WEST SUSSEX COUNTY COUNCIL CONSULTATION

TO:	Arun District Council FAO:Amber Willard
FROM:	WSCC - Highways Authority
DATE:	16 October 2019
LOCATION:	20 Sudley Road Bognor Regis PO21 1EU
SUBJECT:	BR/259/19/PD Notification for Prior Approval under Schedule 2, Part 3, Class O for a proposed change of use from office use on ground floor (B1(a)) into 2 No. flats (C3 Dwellinghouse).
DATE OF SITE VISIT:	n/a
RECOMMENDATION:	Advice
S106 CONTRIBUTION TOTAL:	n/a

Drawing Number 2019/134 Sheet 1 of 1

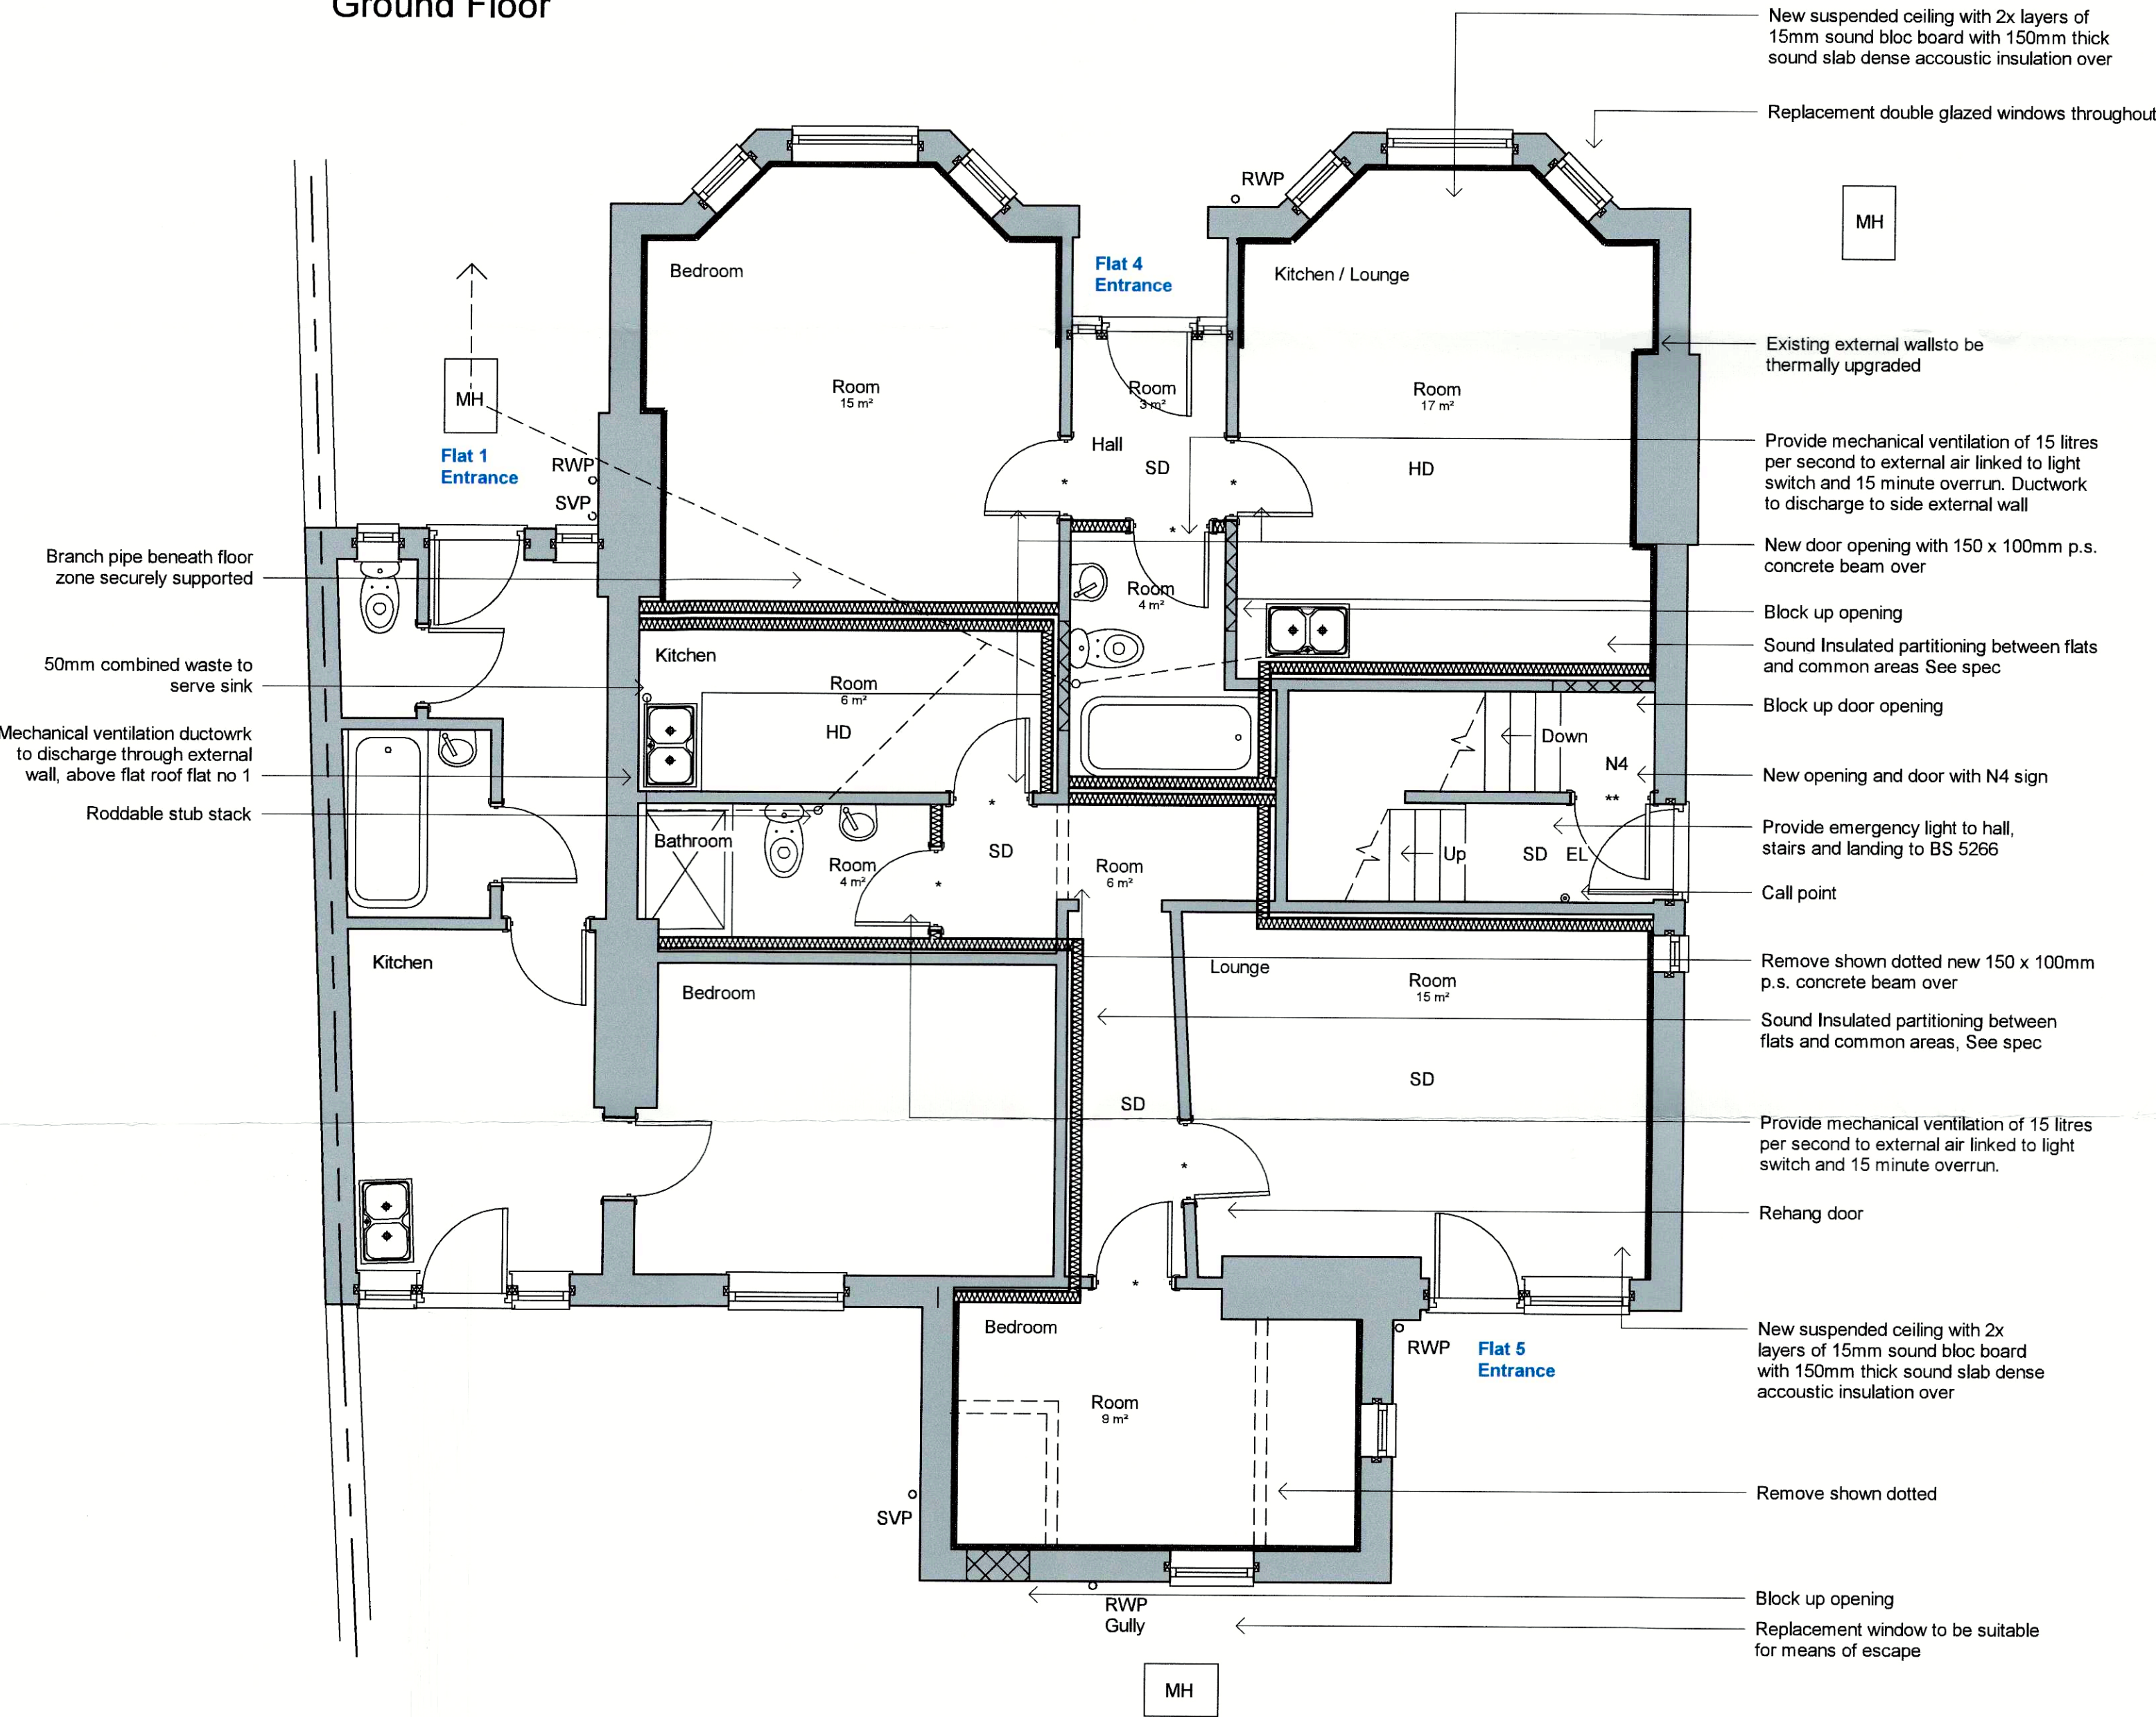
In terms of parking, the application form states that parking provision during construction will be provided to the rear of the property. The proposed plans do not demonstrate parking provision or

layout. It is unclear if any of the existing parking provision will be allocated to the new flats, whether any existing flats will lose parking provision as result of the proposal, and whether parking provision for the existing flats will be impacted during the construction phase.

The Local Planning Authority (LPA) may wish to clarify the parking arrangements for the proposal and consider the impact of any potential on street parking from an amenity point of view.
